Subject: RE: y/10/20/doc

“Engineers Comments Regarding Surface Water Drainage

Further information is required before we can recommend discharging condition 4, the following points require addressing:

Drawing:  
1001

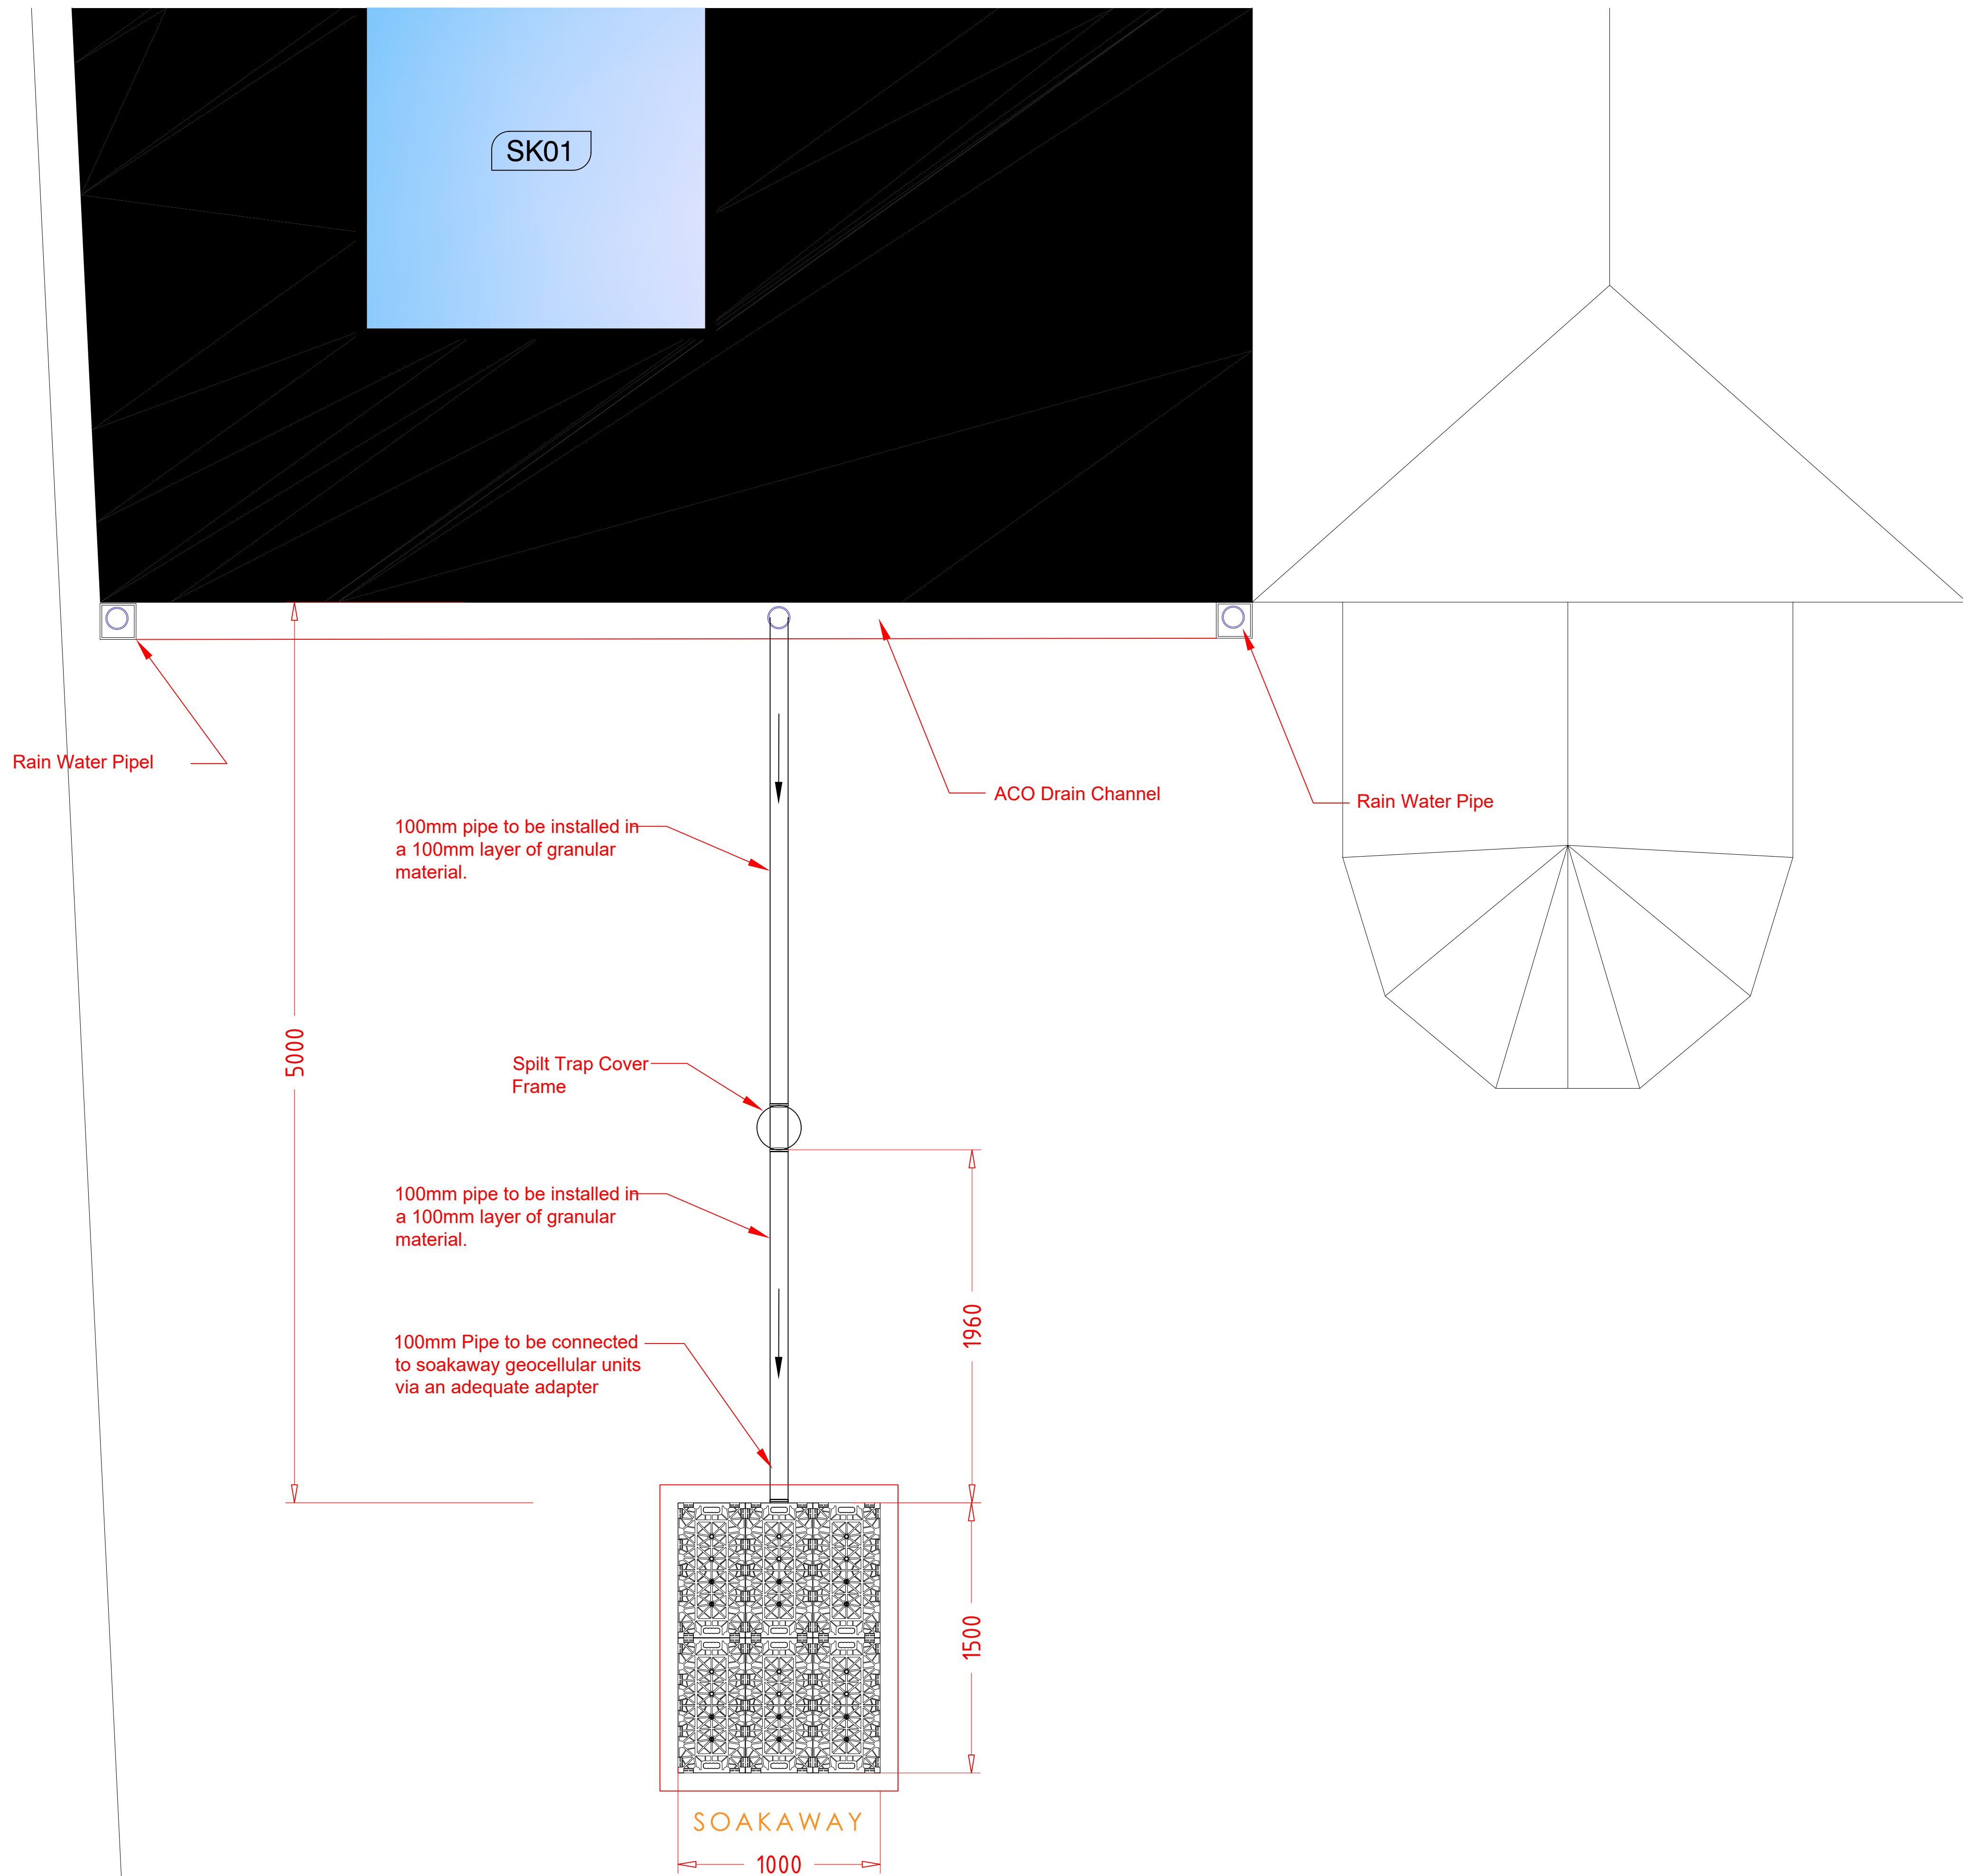
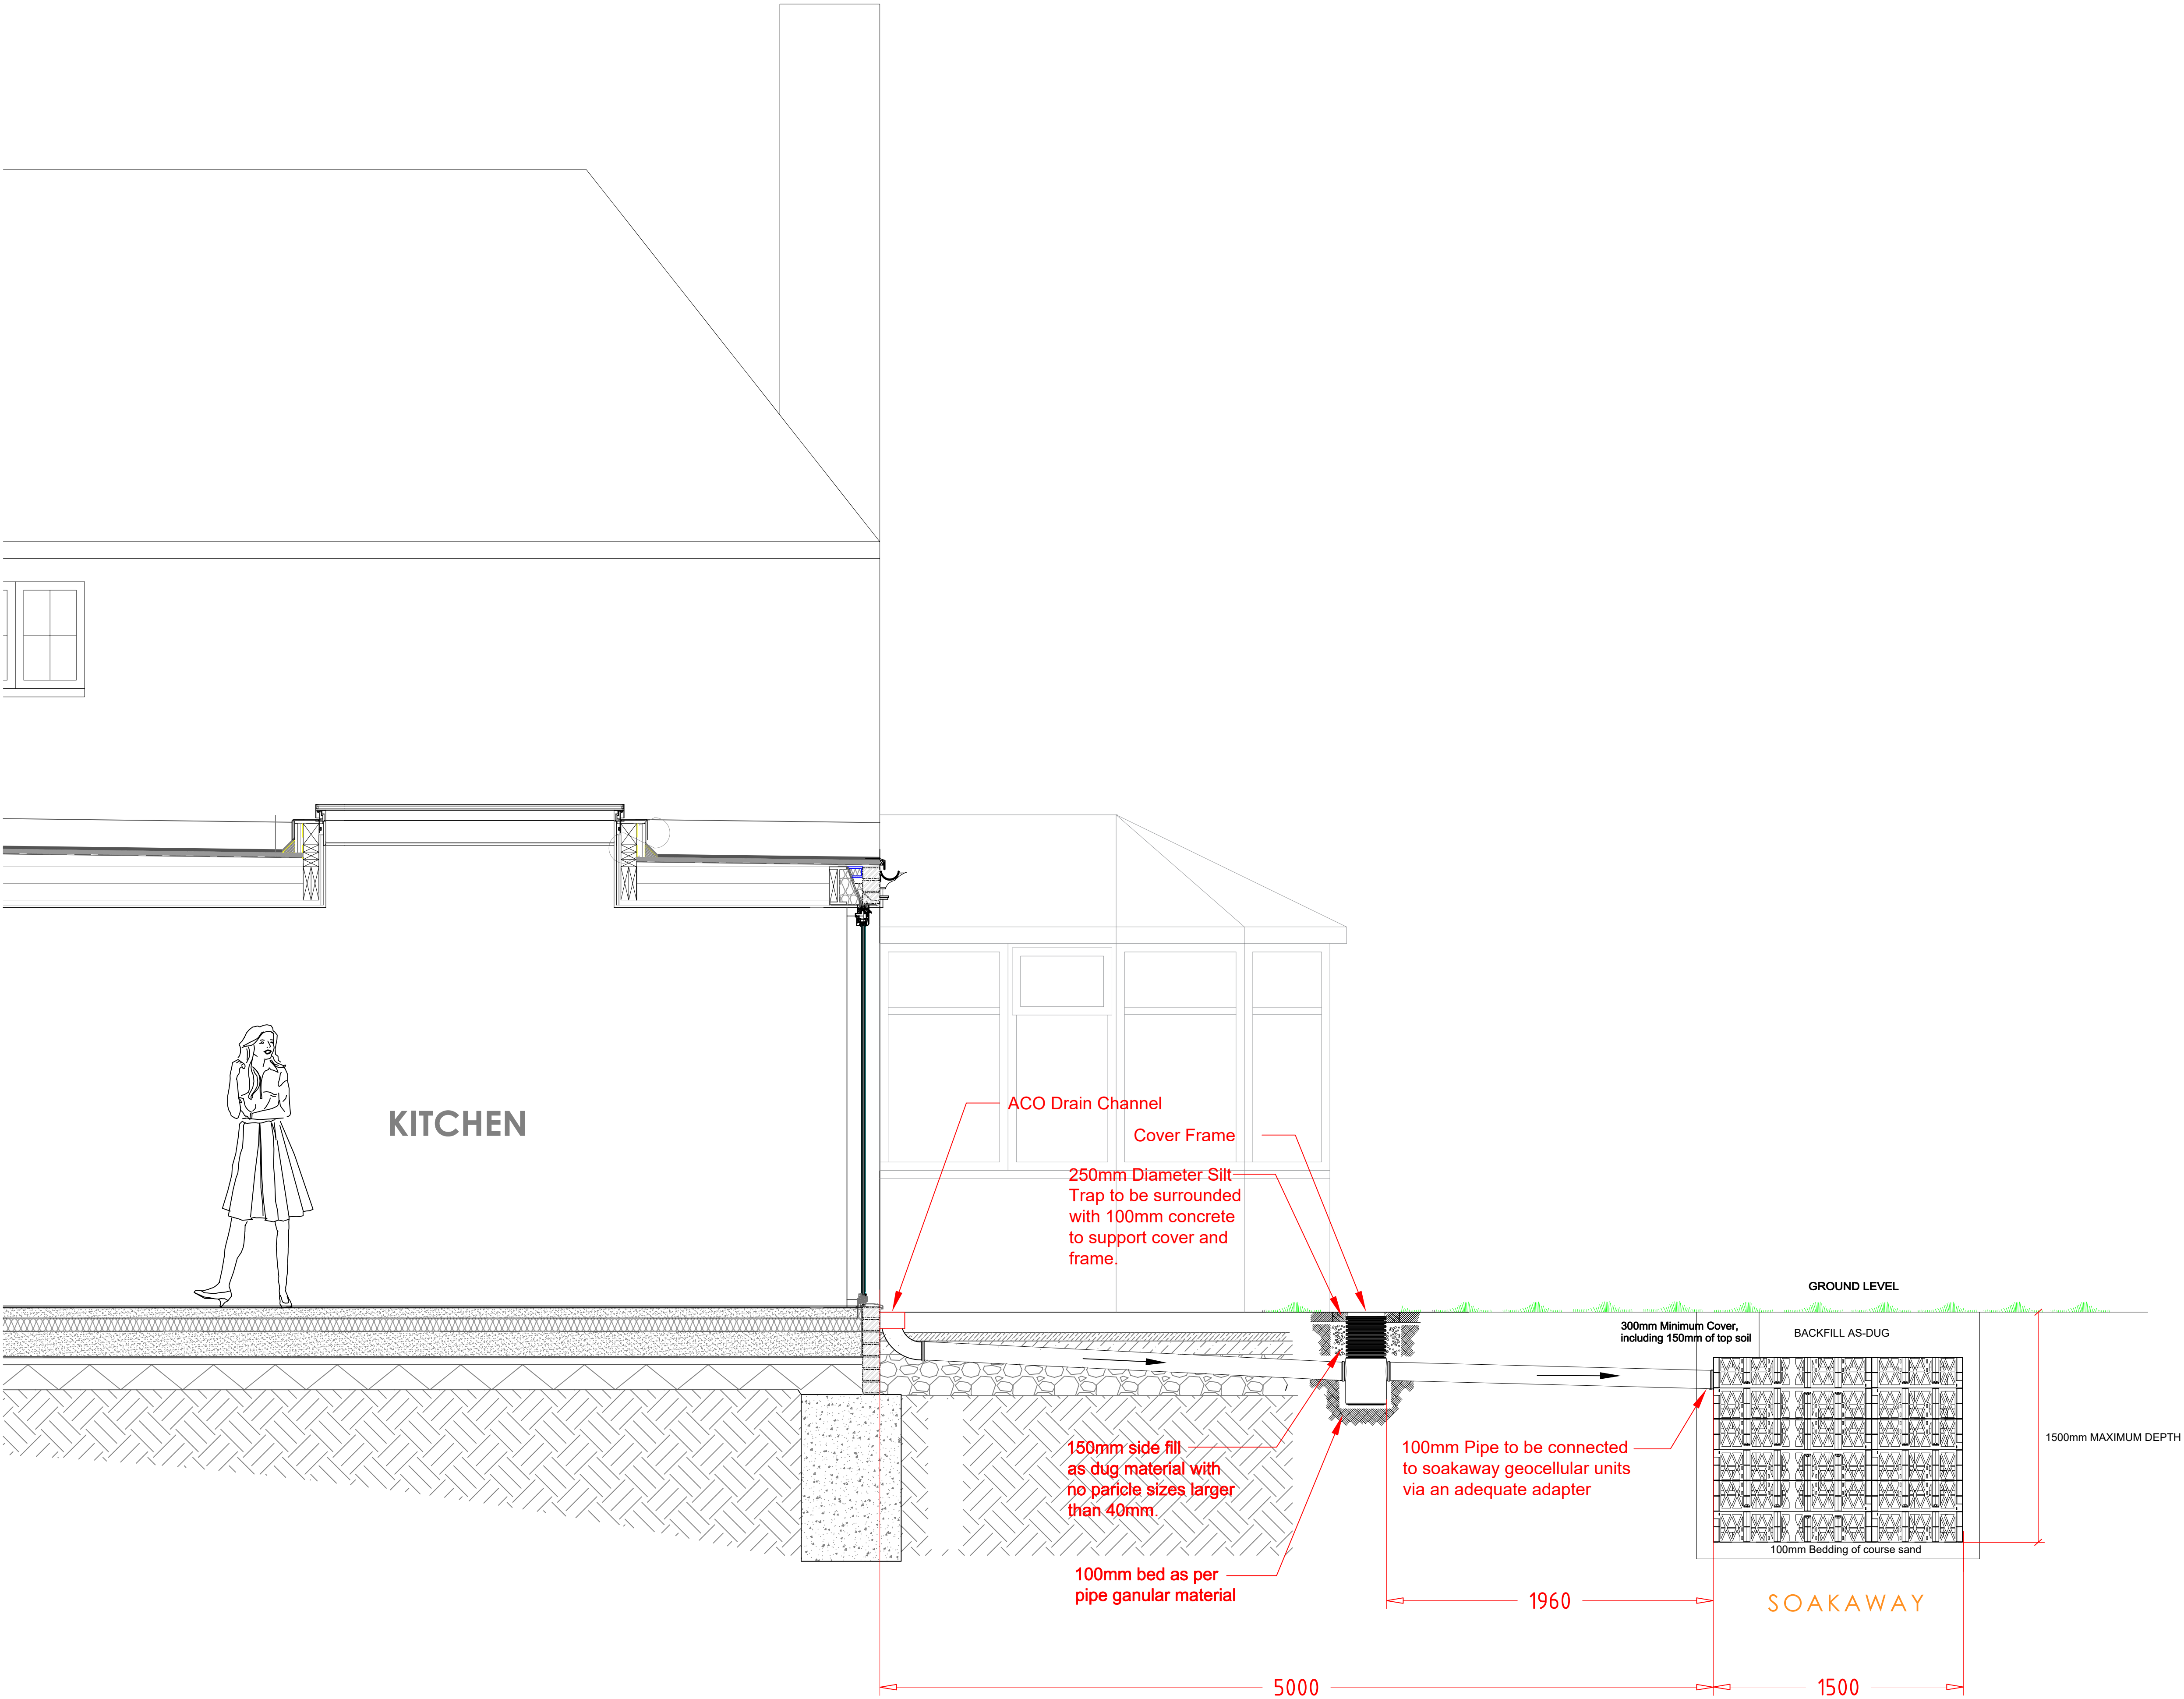
3. No drainage design has been submitted. It is not possible to recommend to discharge this condition without a surface water drainage design. The drainage design included as an image within this document is insufficient in terms of detail and scale. The expectation is that you supply a design which can be used by a contractor on site to construct the drainage as intended. See point 4 below.

4. Assuming that infiltration is viable then we would expect to see the following supplied as part of the DOC application:
- a. Infiltration test results *Not supplied*
 - b. Groundwater monitoring results *Not supplied*
 - c. Soakaway design calculations (to hold and infiltrate up to 1 in 100 +40% storm underground) *Not completed to BRE365 or CIRIA Report 156 as per best guidance. We do not accept calculations to Approved Document H.*
 - d. Drainage layout which includes cover levels, invert levels, pipe diameters, fall and gradients as well as soakaway dimensions, and location of silt trap. *Not supplied.*
 - e. Construction detail drawings for soakaway, silt trap and pipe bed and surround. *Not supplied.*
